From: Larned, Kimberly - FS, WA <kimberly.larned@usda.gov>
Sent: Thursday, December 11, 2025 3:34 PM
To: Ellie Myers
Subject: RE: [External Email]RU-25-00003 Sage - Notice of Application

CDS is requesting comment on the following Reasonable Use Application: RU-25-00003 Sage. Links to the file materials can be found below. The comment period will end **December 29, 2025, at 5pm**. CDS will assume your agency does not wish to provide comment if not received by this date. Please let me know if you have any issues accessing the materials.

RU-25-00003 Sage Hazardous Slope

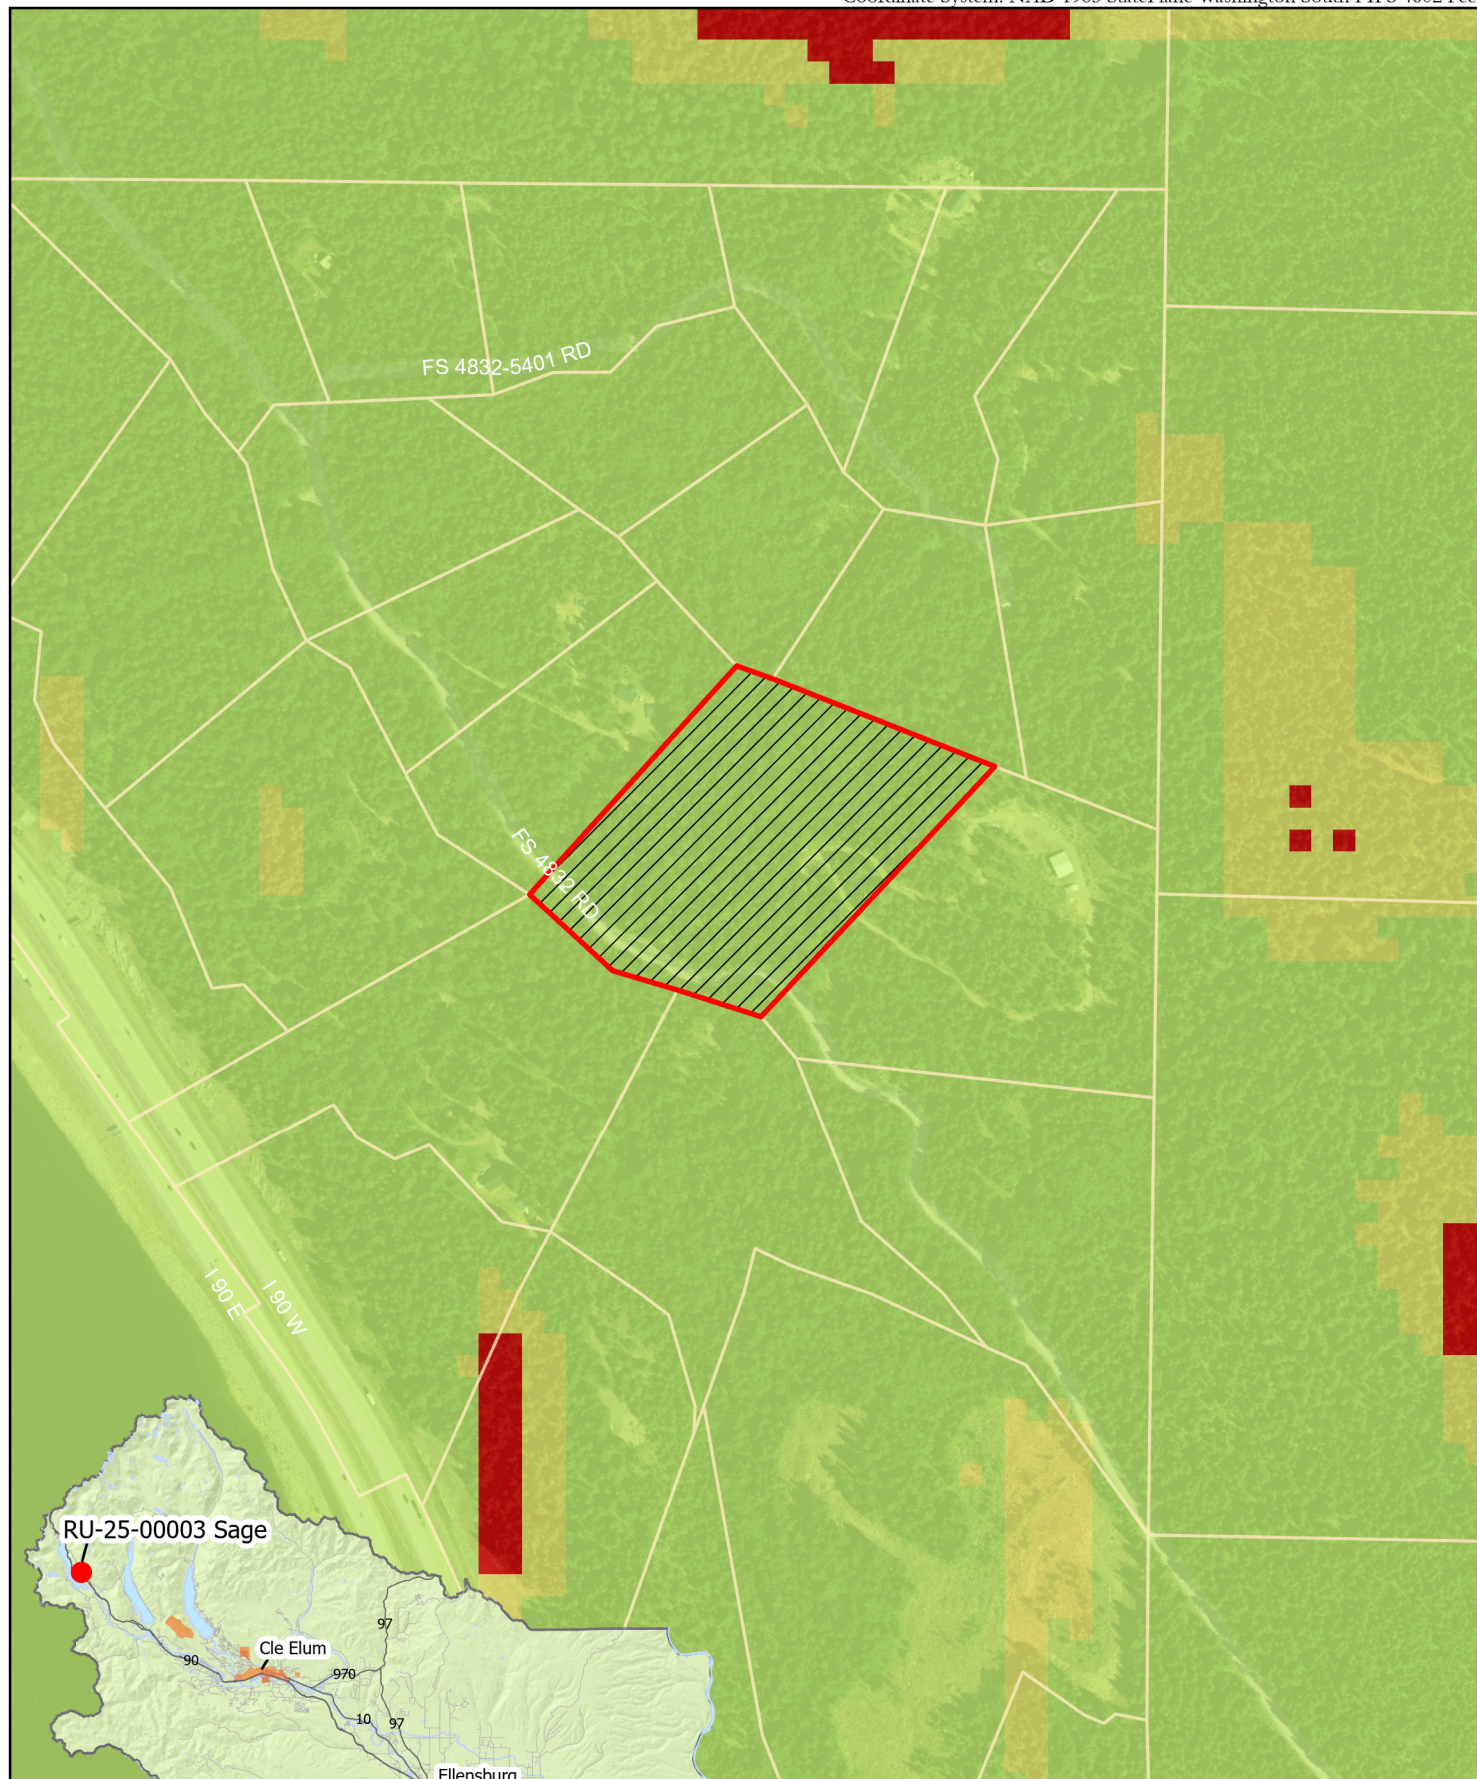
The map is incorrect showing the location of Forest Service Road 4832. I believe the road that is showing on the map labeled as 4832 is a private road and Forest Service Road 4832 is on the southwest end of the parcel.

Please double check me on this...
